Town & Country Planning Act 1990 (as amended)
Town & country Planning (Development Management Procedure) (England) Order 2015
Application for Planning Permission for Works or Extension to a Dwelling

Development Single storey and two storey extensions, creation of additional habitable roofspace, and alterations including external rendering and cladding

Location Little Glebe Little Heath Road Fontwell Arundel

Drawing P04a Sept 2018 Scale 1:100, 1:500 & 1:1250 @ A2
Planning Drawing - Roof Plan, Block Plan & Location Plan

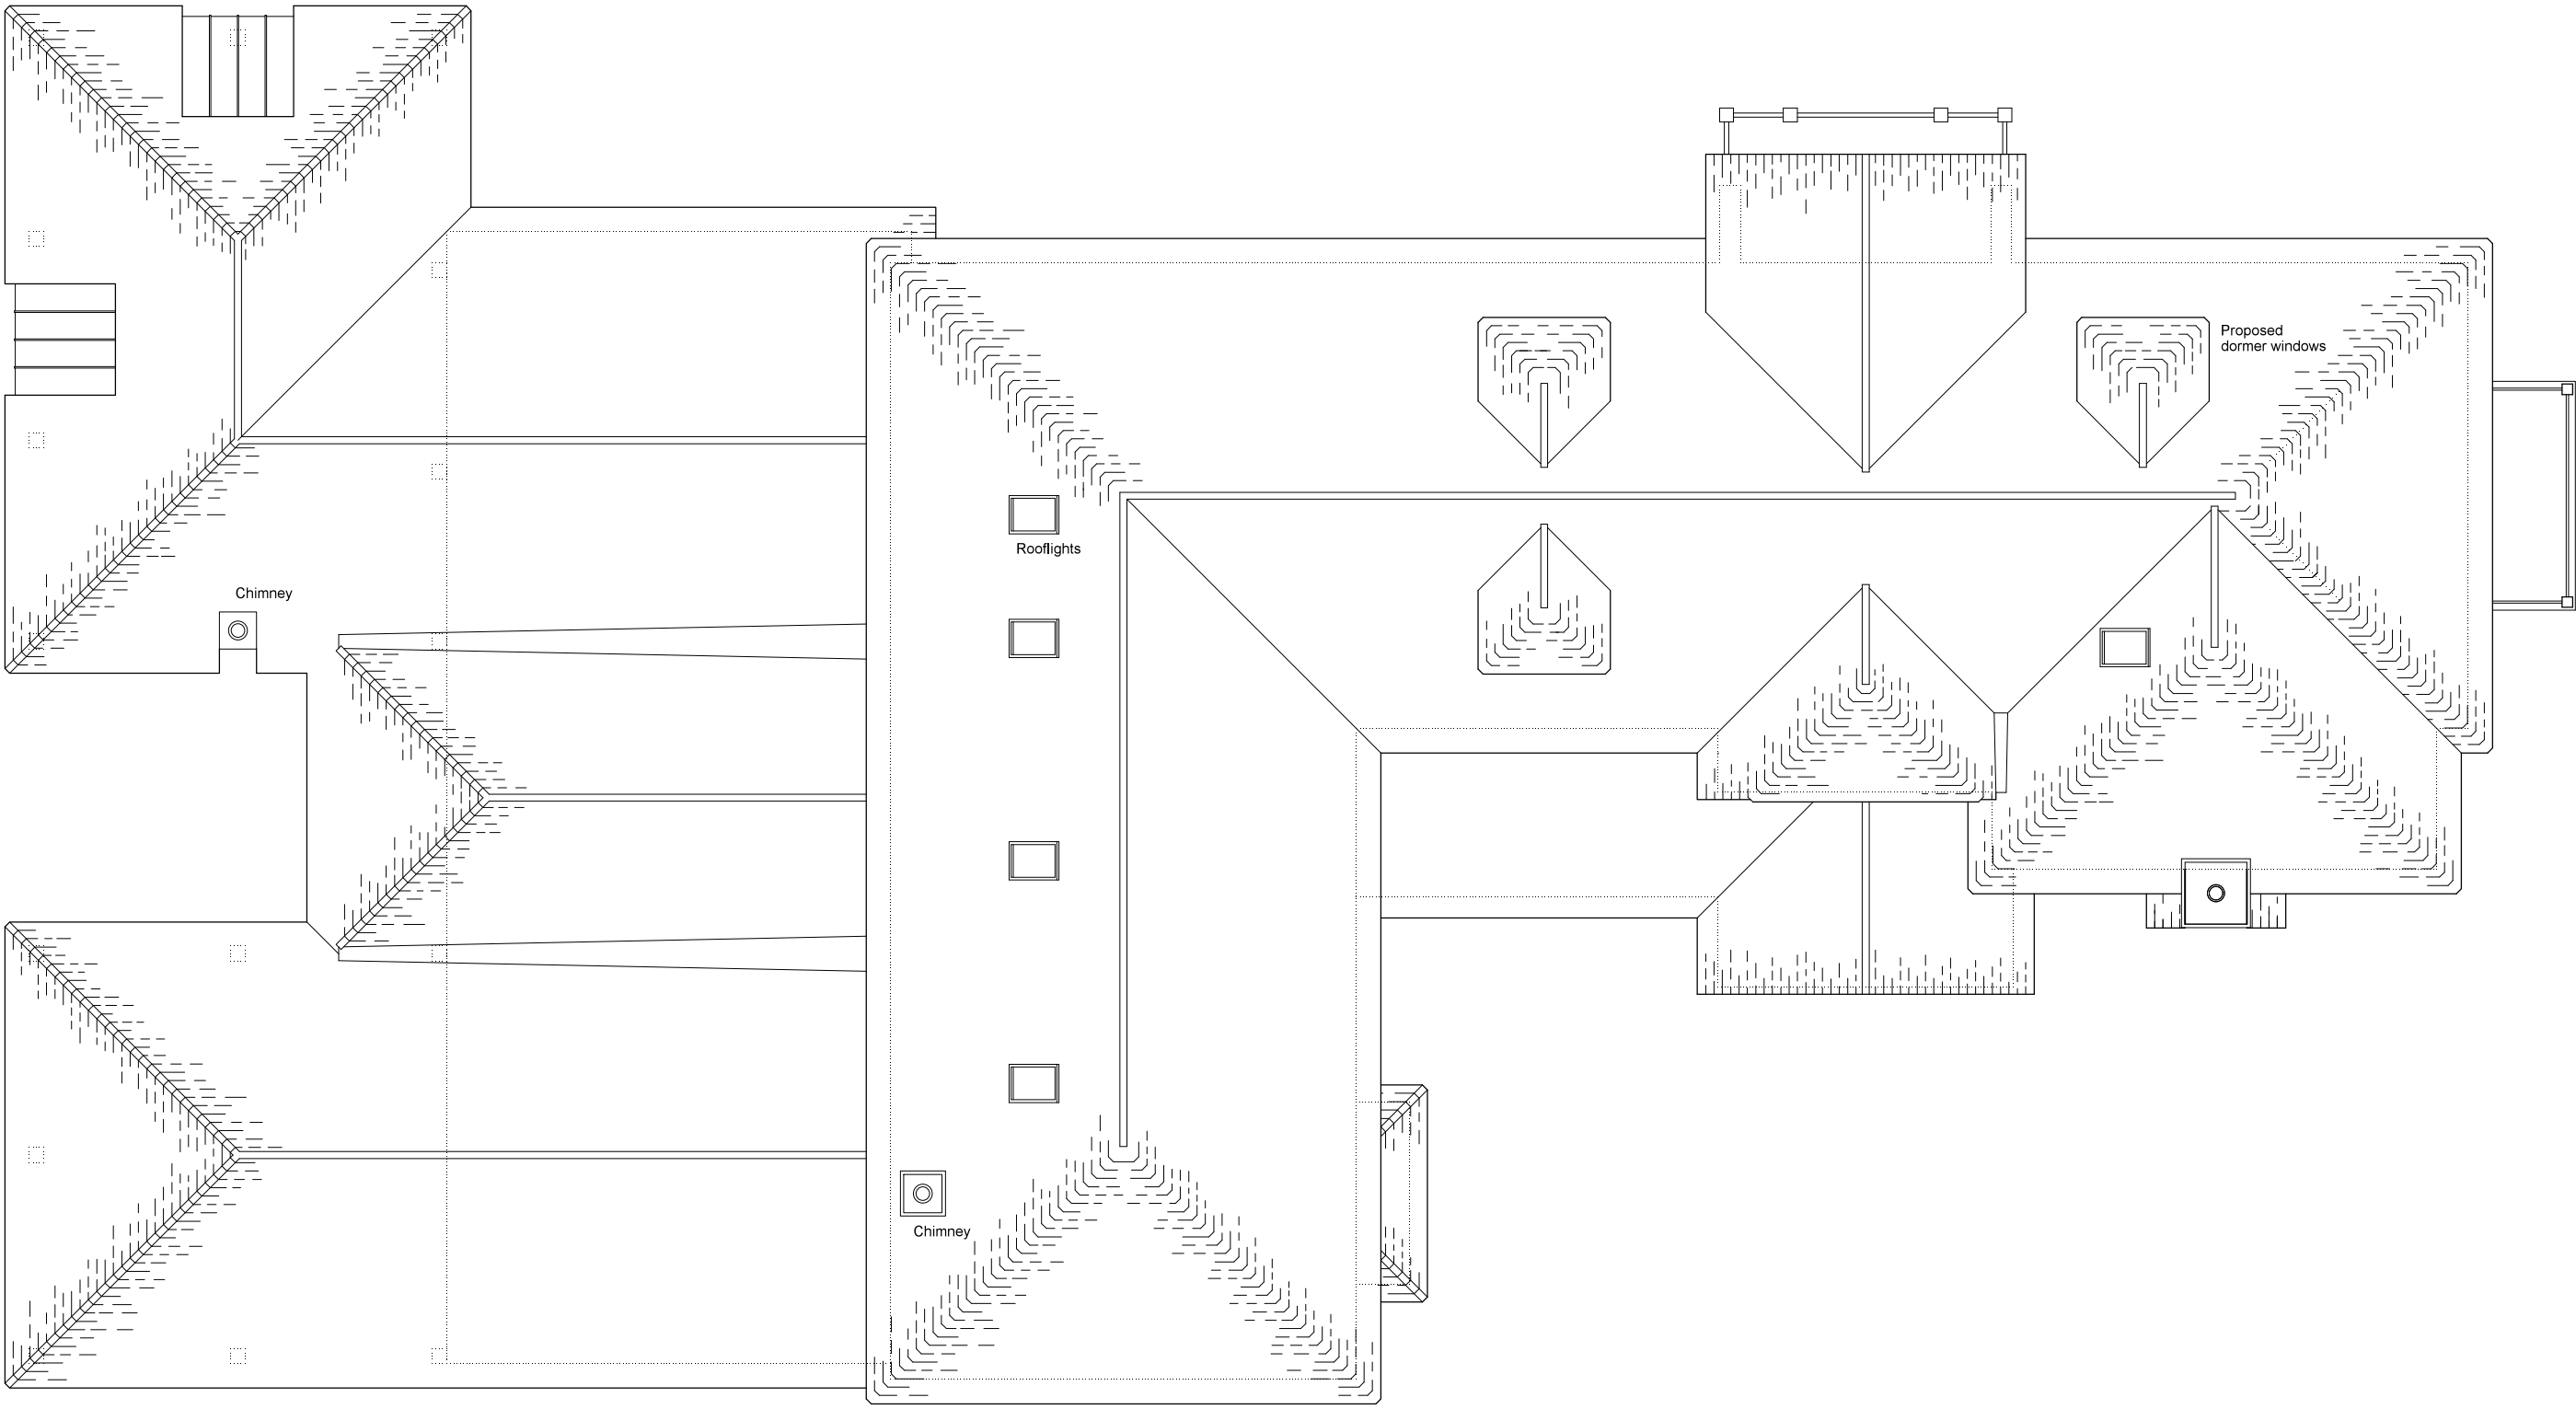
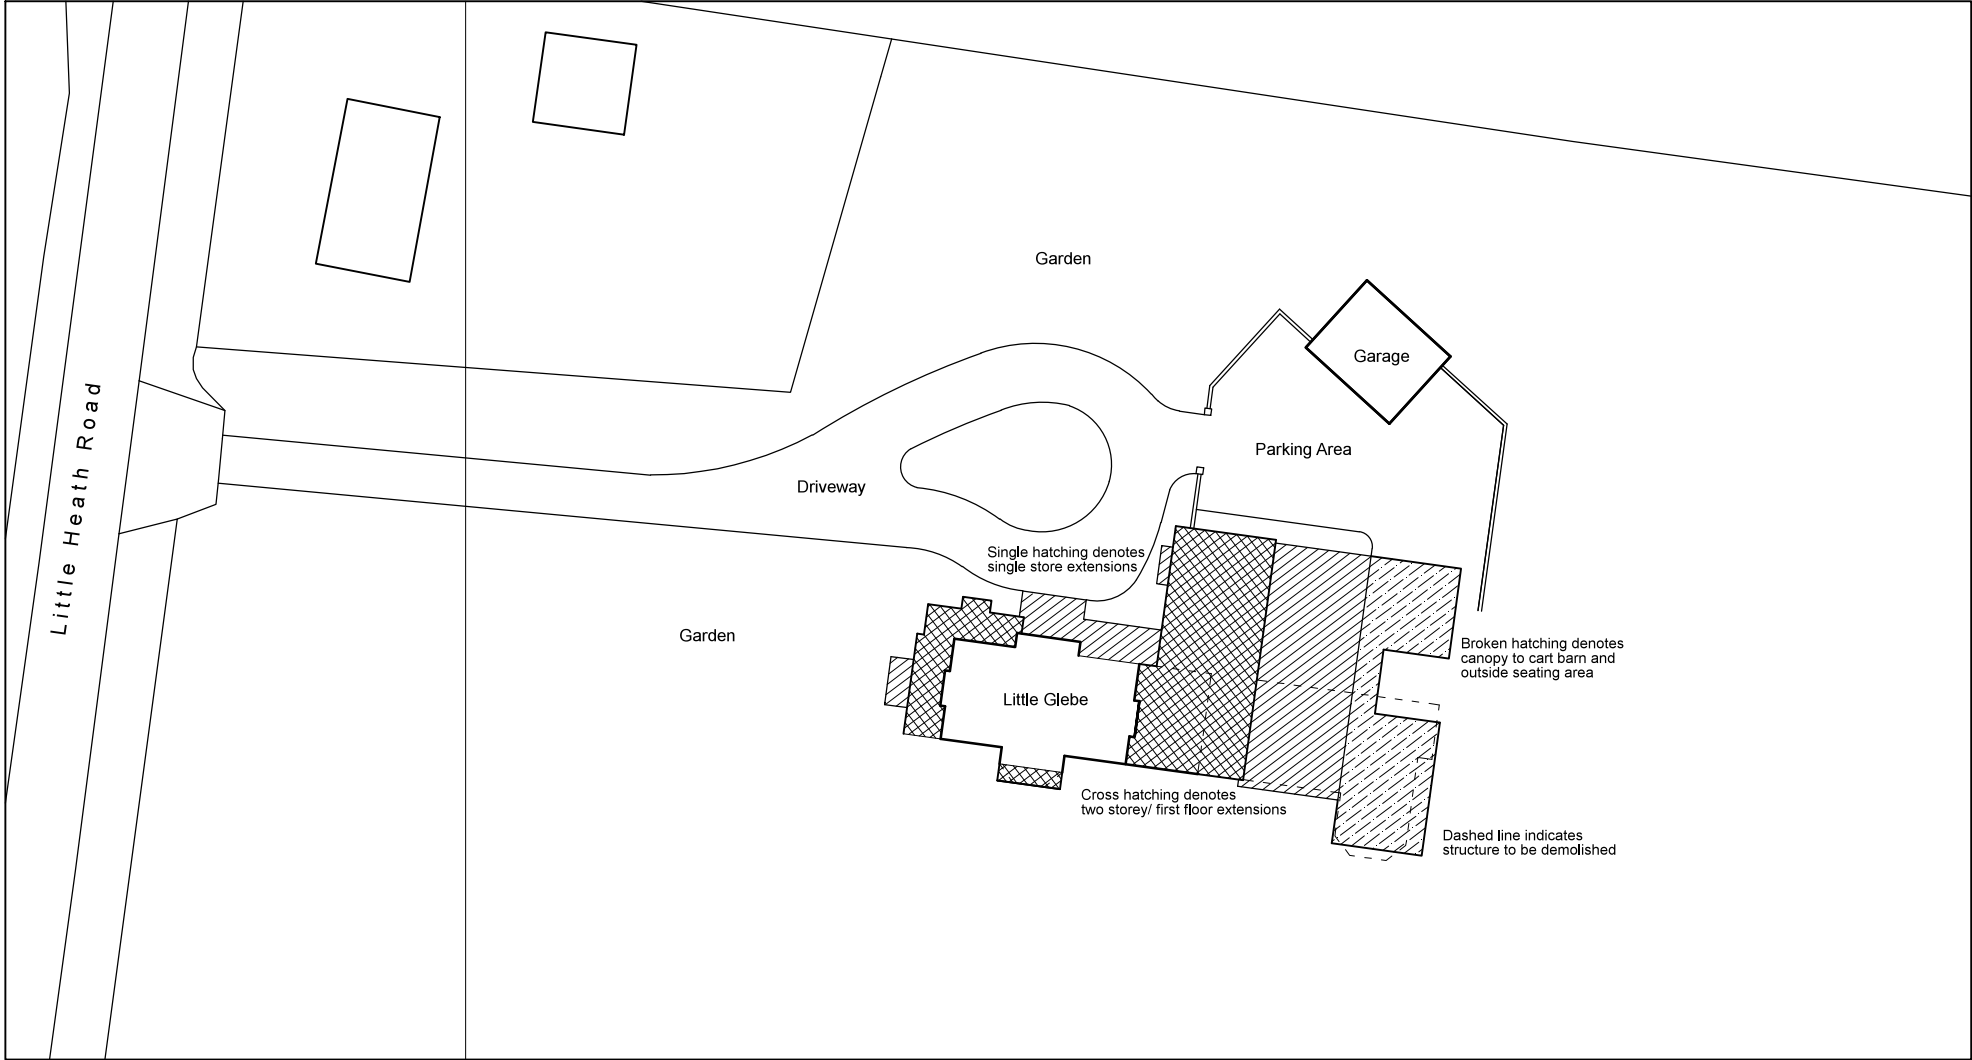
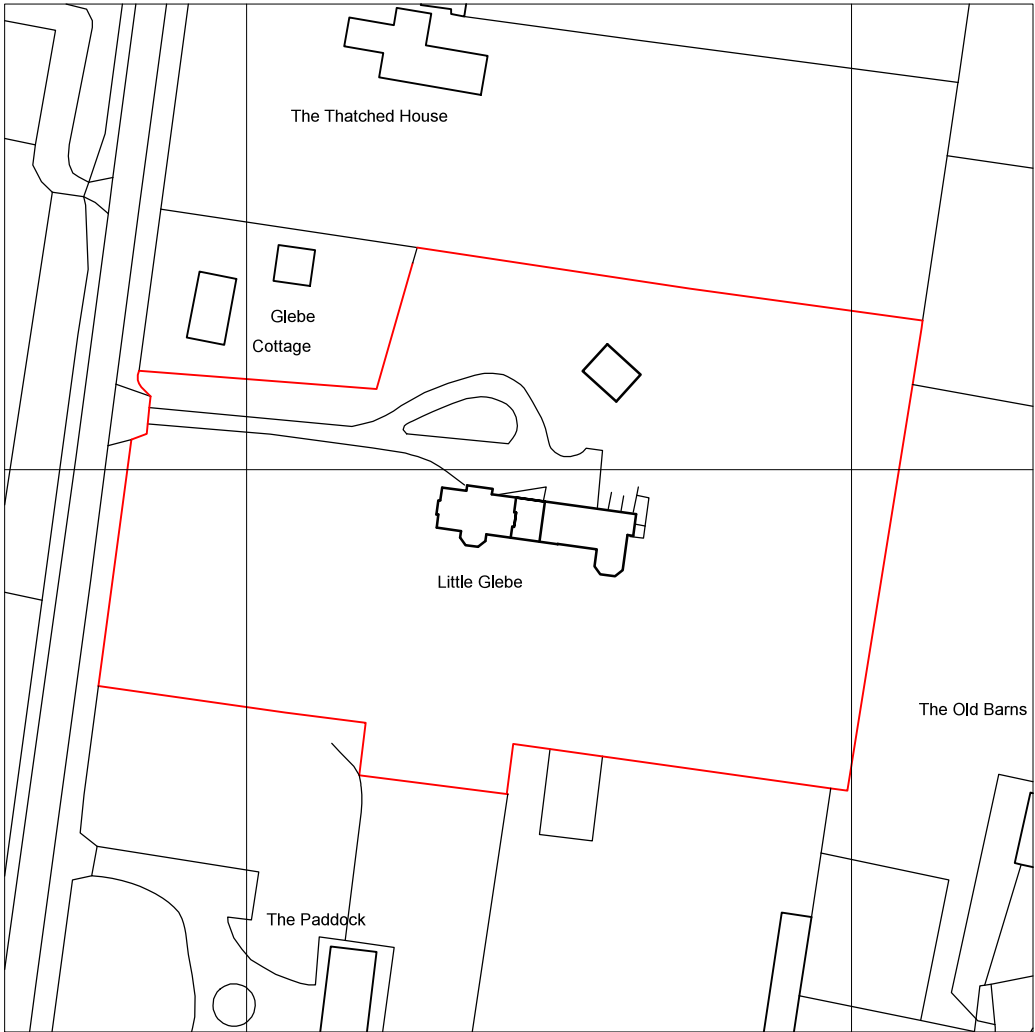
Please provide a block plan showing all site boundaries. You are required to annotate dimensions to show the distance between the proposed extensions and the site boundaries.

The roof does not match between the proposed roof plan and the second floor plan and the proposed north, south and west elevations.
